STATE OF NORTH CAROLINA
DEPARTMENT OF TRANSPORTATION

Subject: Permit modification request for the proposed improvements to US 17 in Onslow, Jones and Craven Counties, TIP No. R-2514B, C & D.

Reference: Section 404 Permit Action ID SAW-2008-00528 issued May 22, 2015
Section 401 Water Quality Certification No. 004012 issued March 2, 2015
NCDWR Project No. 20141169v1
N.C. Coastal Area Management Act Permit 43-15 issued March 24, 2015

PROJECT REFERENCE NO.	SHEET NO.
R-2514D	9
R/W SHEET NO.	
ROADWAY DESIGN ENGINEER	HYDRAULICS ENGINEER
PRELIMINARY PLANS DO NOT USE FOR CONSTRUCTION

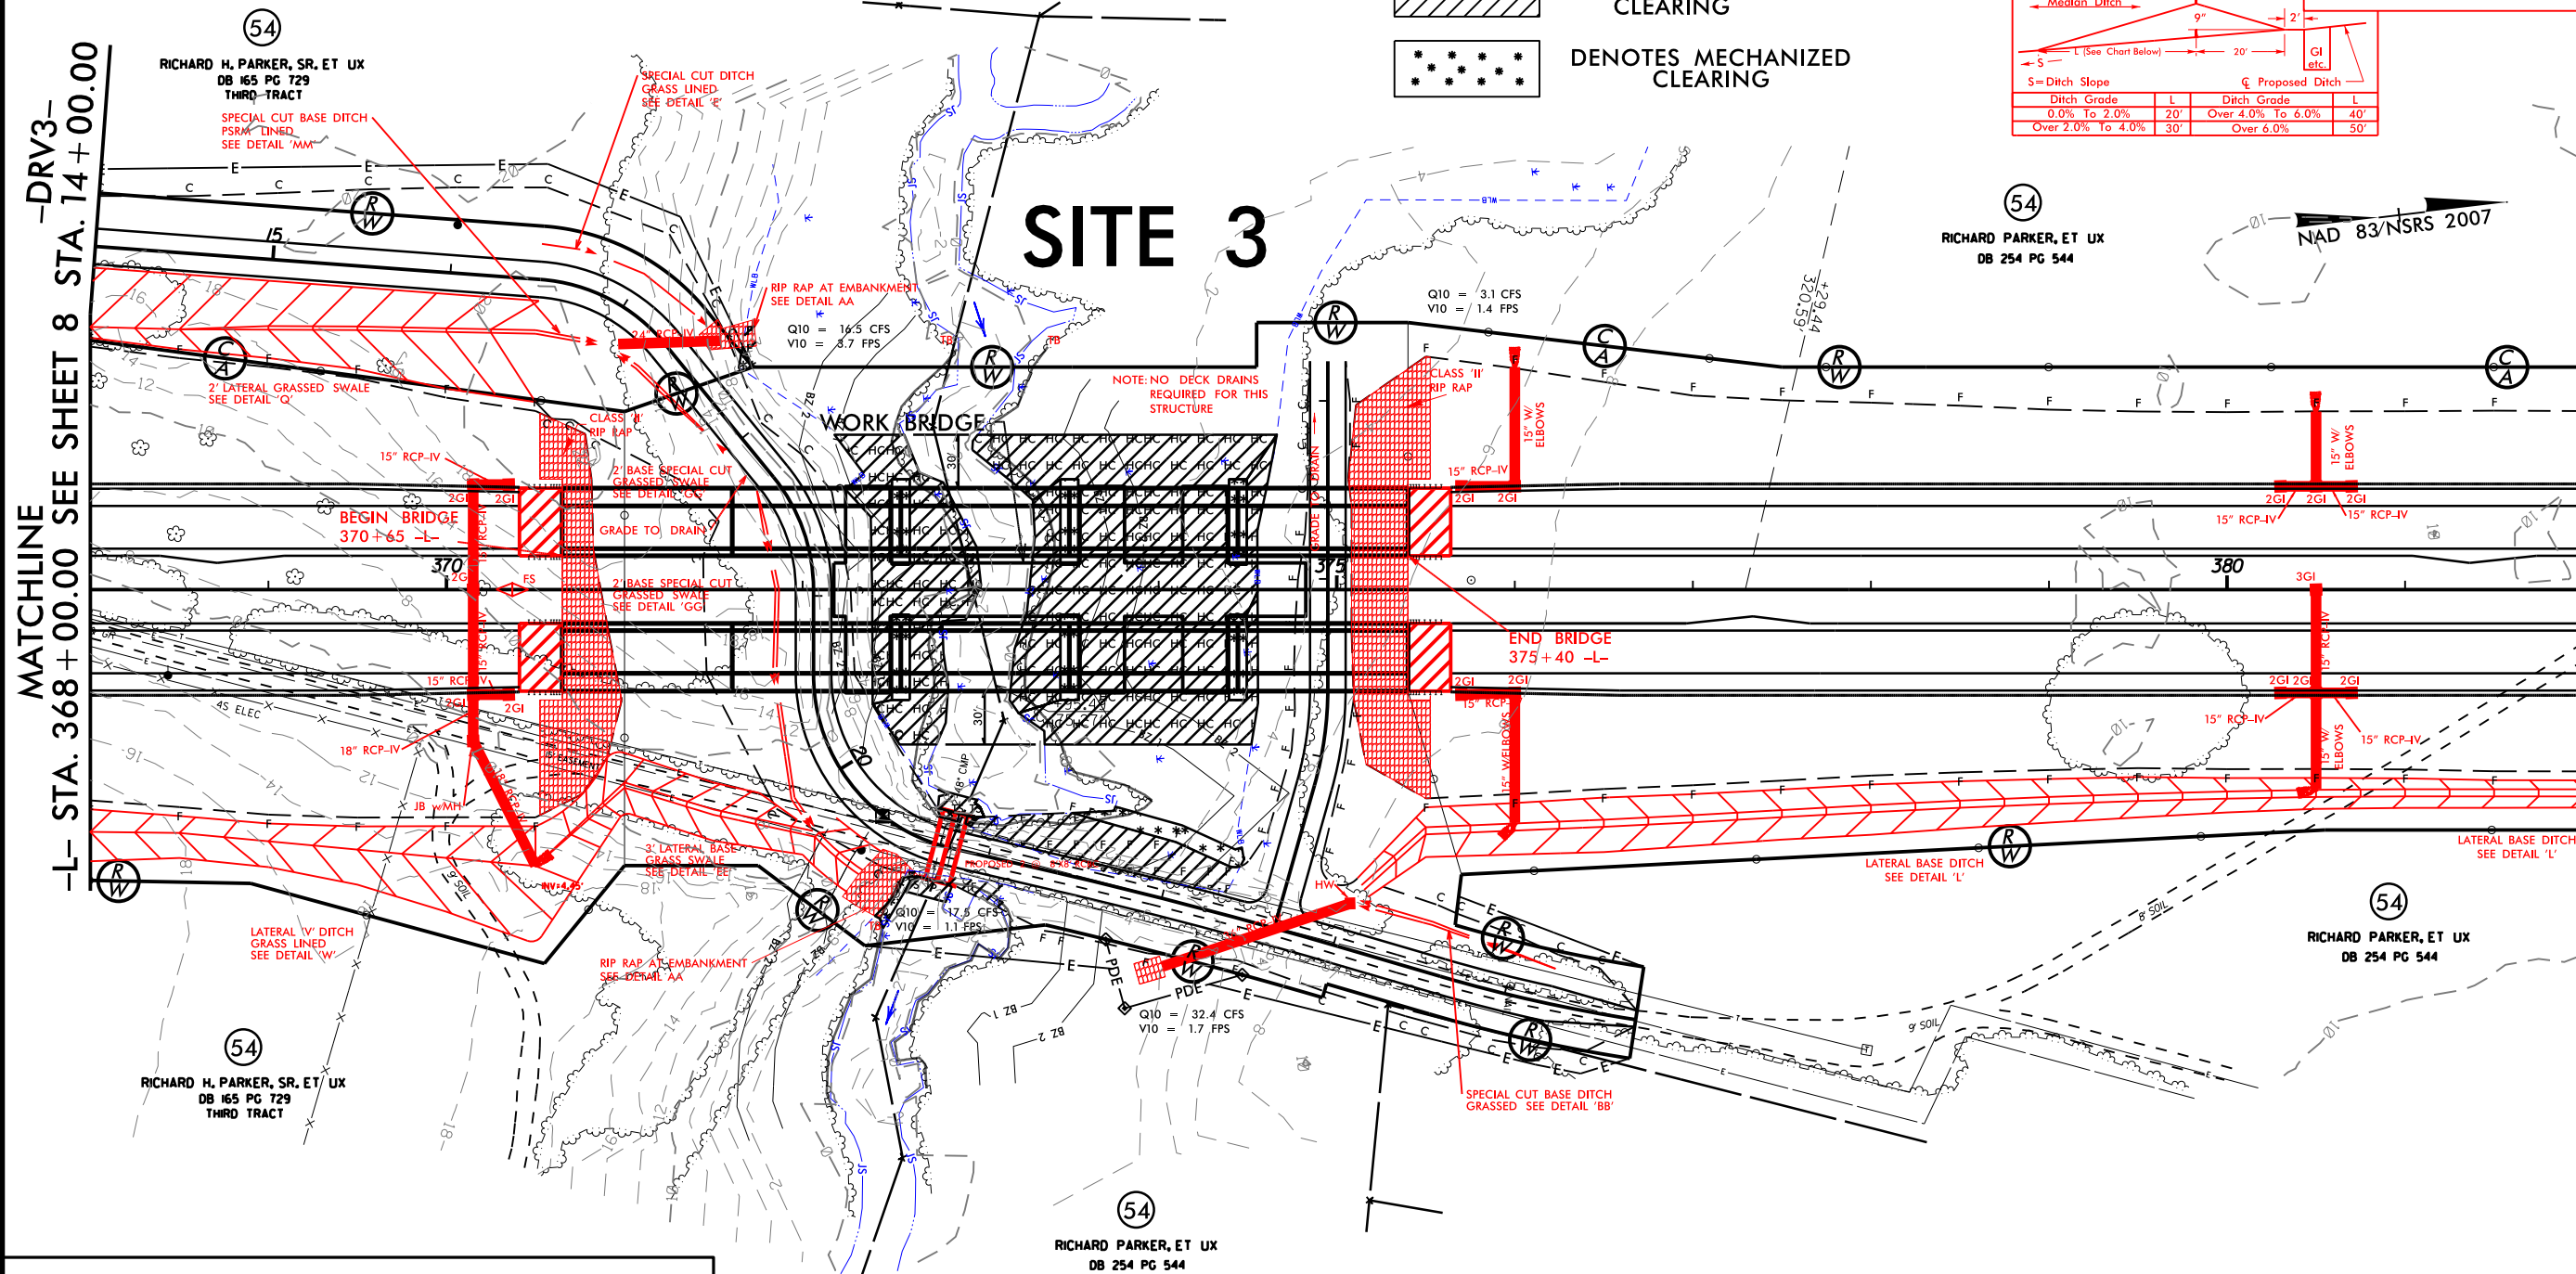
As you are aware, the North Carolina Department of Transportation (NCDOT) is constructing improvements to US 17 from SR 1330/SR 1439 south of Belgrade to the New Bern Bypass. Permits for this project were issued in 2015, and the project was let to construction on June 16, 2015. The NCDOT is requesting a permit modification to allow for changes the contractor wants to make at permit Site 3 on Goshen Branch northeast of Pollocksville on section R-2514D (sheet 9 of the highway plan sheets).

The contractor, Mountain Creek Contracting, would like to use a bypass channel to build a culvert. If allowed to proceed, this will minimize environmental impacts to one channel change as well as speed up production. They are requesting that the permits and erosion control plans be revised to reflect the attached revised plan sheet 9 for R-2514D.
